DRB Application No.: 03-01427 (P&F)  
Project Name: VALLEY VIEW ADDITION  
Agent: Bohannan Huston Inc.

DEVELOPMENT REVIEW BOARD--SPEED MEMO

**CITY OF ALBUQUERQUE  
PLANNING DEPARTMENT  
Development Review Board  
September 3, 2003 Comments**

**RE: Valley View Addition/ Prelim & Final Plat**

**PLAT OF
 LOT 19-A, BLOCK 37
 VALLEY VIEW ADDITION**
 (A REPLAT OF LOTS 19 THRU 40
 VALLEY VIEW ADDITION)
 ALBUQUERQUE, NEW MEXICO
 AUGUST, 2003

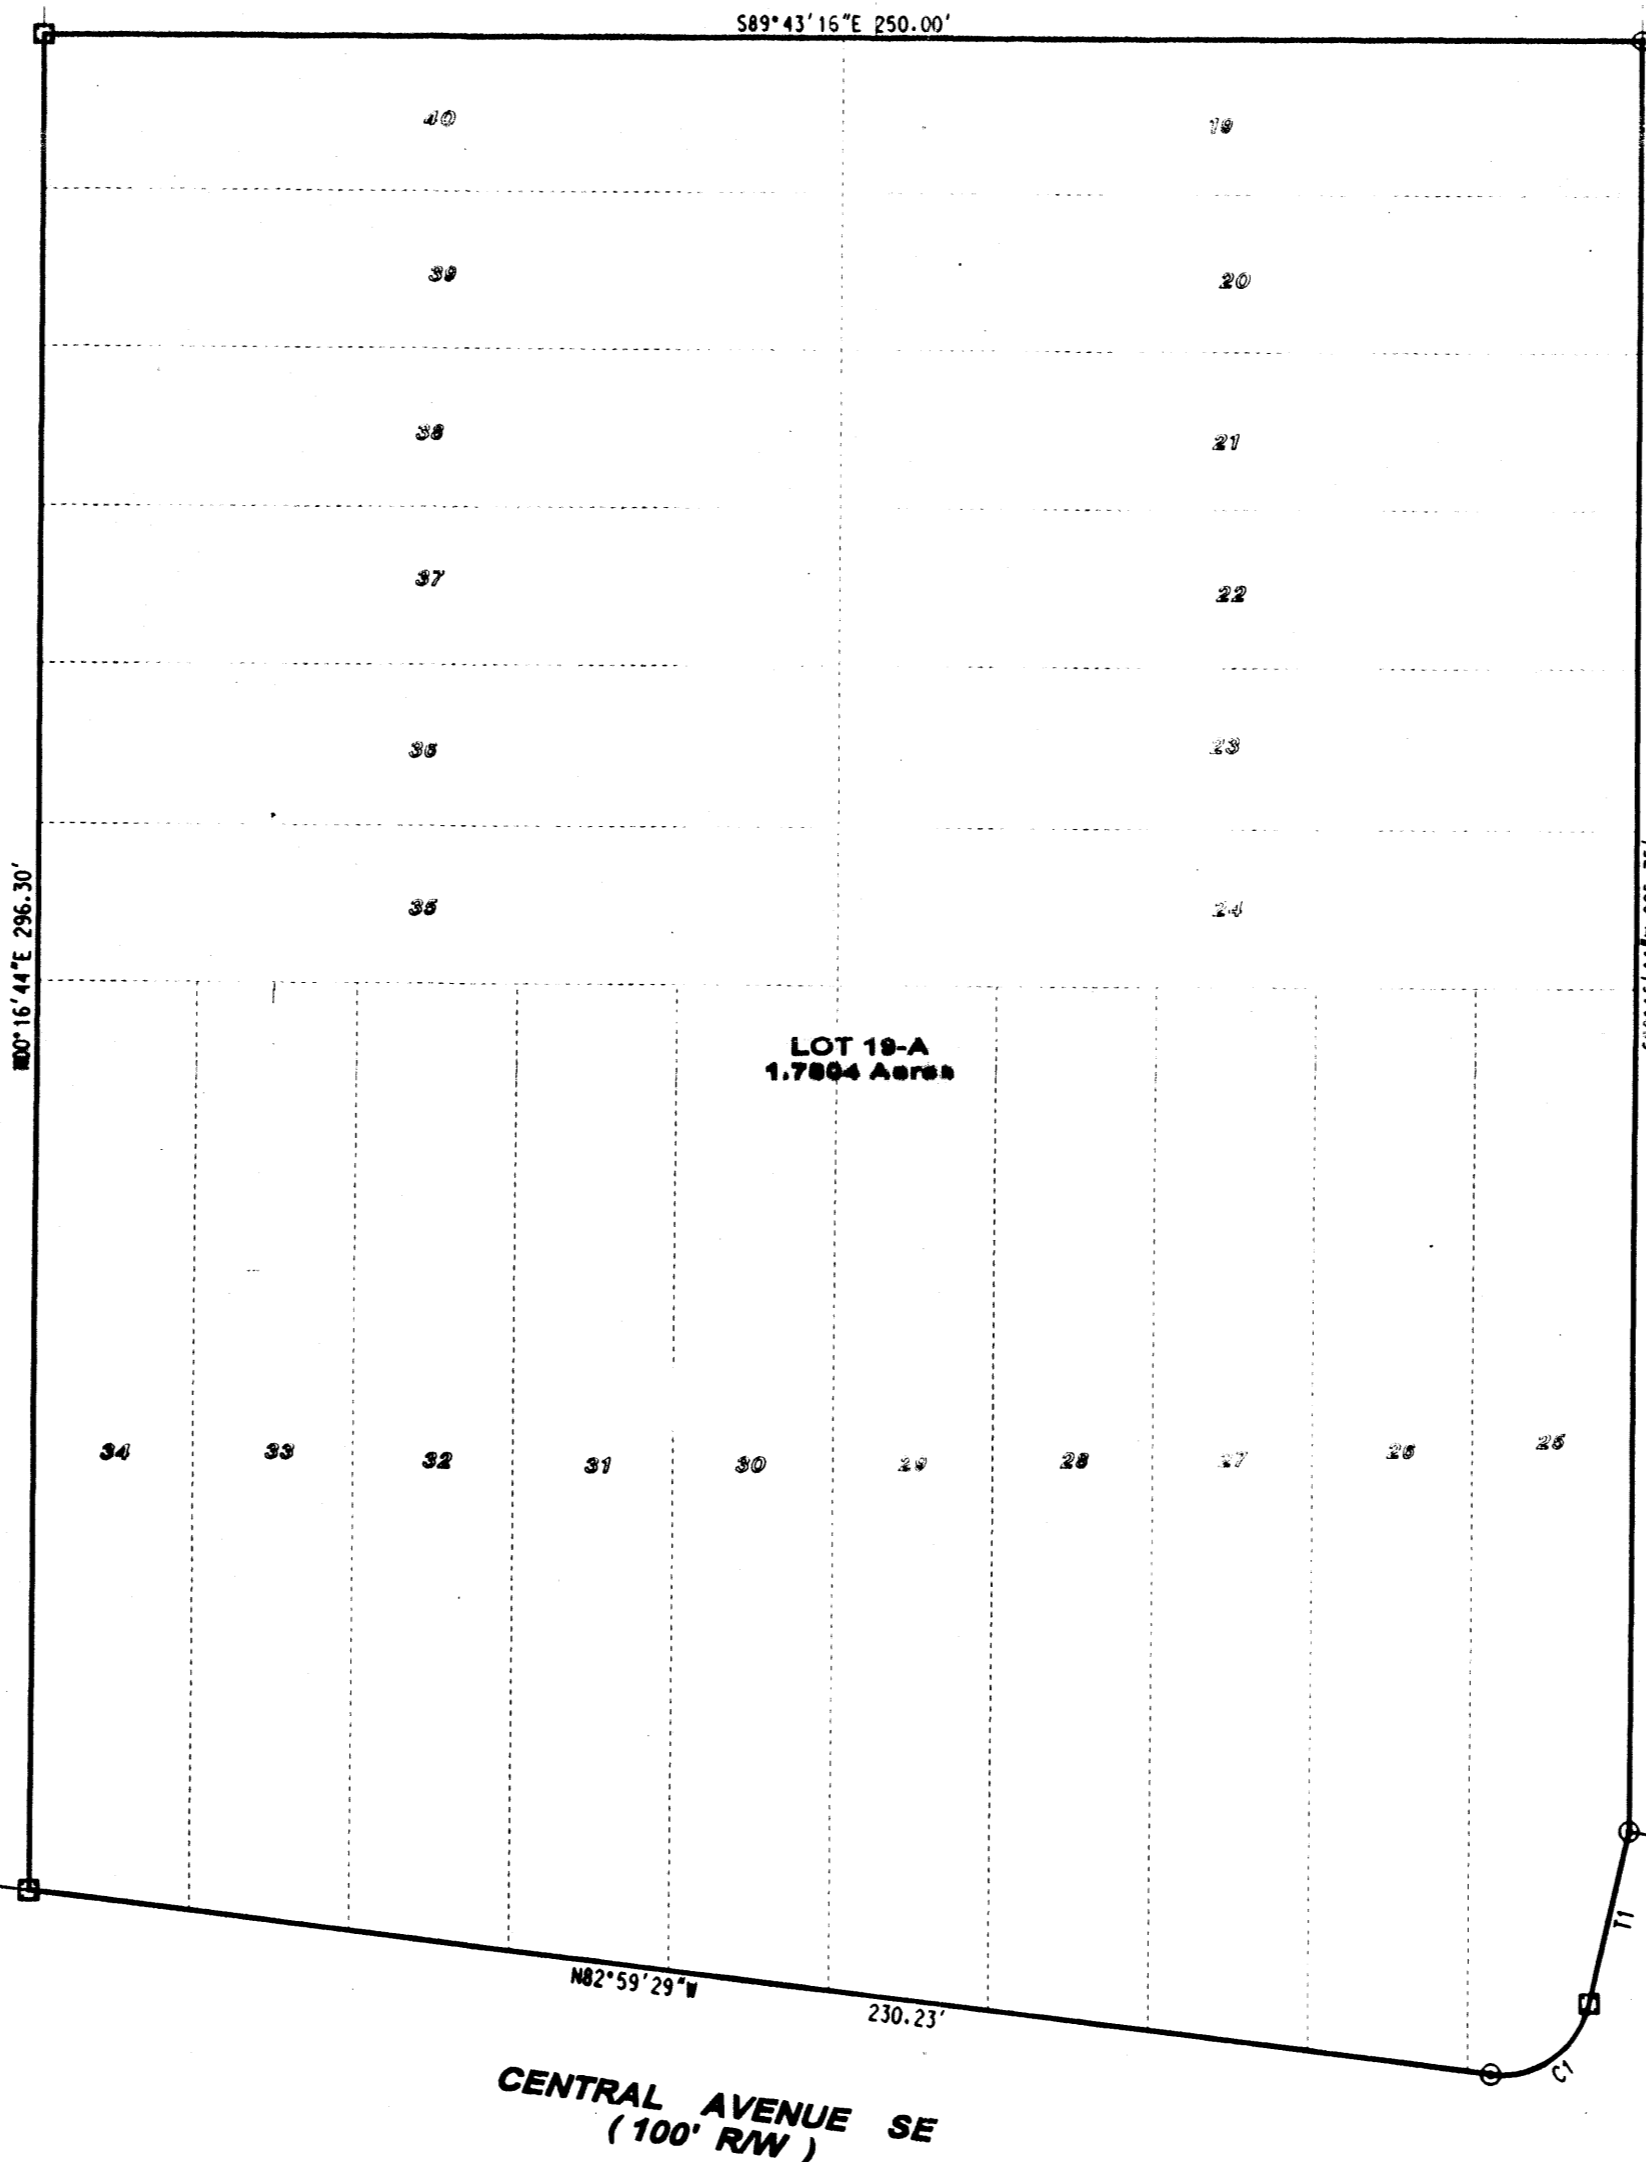
TRANSPORTATION: Dedicate 30 R/W. 10 ft from face of curb

No.	Comment
<input type="checkbox"/>	10ft from the face of the curb needs to be dedicated as right-of-way along the perimeter streets.
